Javier Cannon
Senior Environmental Assessment Officer
DPE - Planning

Assessment of Peninsula Solar Farm (SSD-14757962) (Forbes Shire)

21 October 2022

Figure 8. Land and Soil Capability Mapping

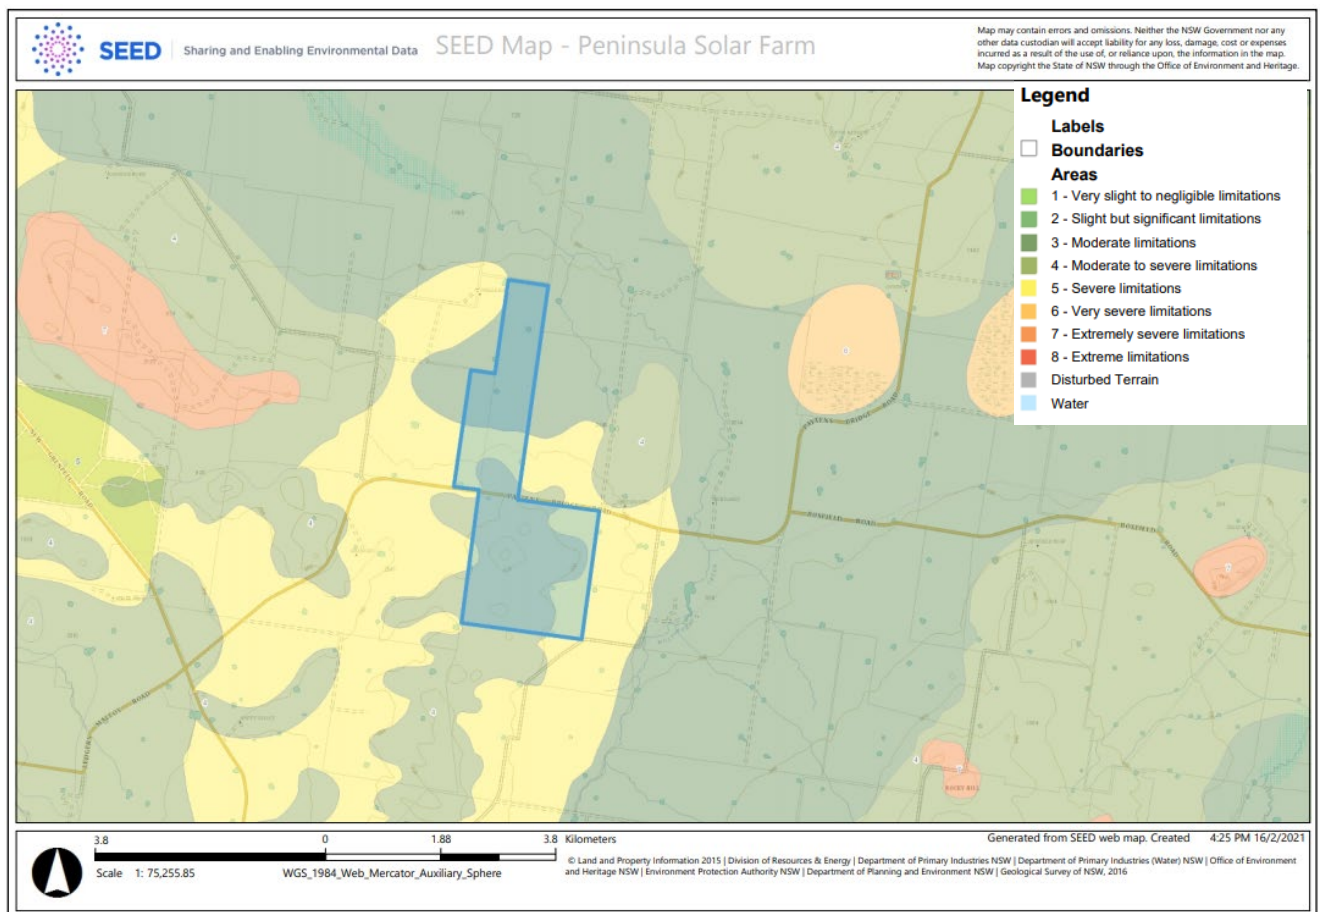
- reference to the northern parts of the most northern lots being mapped as State Significant Agricultural Land (SSAL) under the current draft mapping which indicates the importance of such land in the state.
- land identified as having a land and soil capability (LSC) of 3, 4 and 5.
- on-site assessment of land or soils undertaken in relation to agricultural land uses.

Ideally an Agricultural Impact Statement (AIS) should have been undertaken. This is because of the proposal's long-term removal of land from production with a Land and Soil Capability of Class 3. The AIS should include an assessment of agriculture on the site and in the locality, changes due to the solar development on agricultural enterprises and production values during construction and operation, including any land sharing arrangements. The AIS should also include an assessment of the state-wide scarcity of highly productive agricultural land and the relative amount of LSC class 3 and SSAL lands.

Final land rehabilitation outcomes are to include details of the baseline soil profile analysis showing extent and soil types over the project site to determine site specific LSC predevelopment, and to inform final land rehabilitation outcomes.
